Your ref: 3/2019/0763
Our ref: DC/19/3568
Date: 06-SEPT-19

Location: Land off Ribblesdale View Chatburn
Proposal: conditions - 17 (surface water drainage), 18 (sustainable drainage plan),

SJ Bialecki Limited Building Surveyors
Drawing no 6002/d
Scale 1:100
Proposed Site Layout
Proposed Residential Development On Land At Ribblesdale View Chatburn

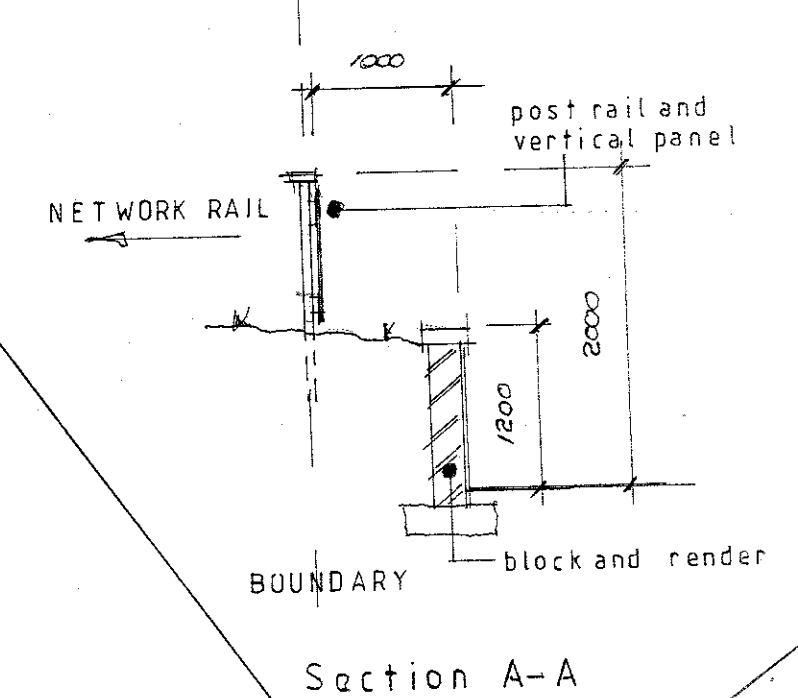
Further to our review of the submitted documents, United Utilities recommends that condition 17 is not discharged.

This is because the submitted plan does not show enough detail to confirm the proposals are in line with the planning condition.

As a minimum we would like to see the plan confirming an adherence to the rate of discharge stated in condition 17 which has been set at 10 l/s.
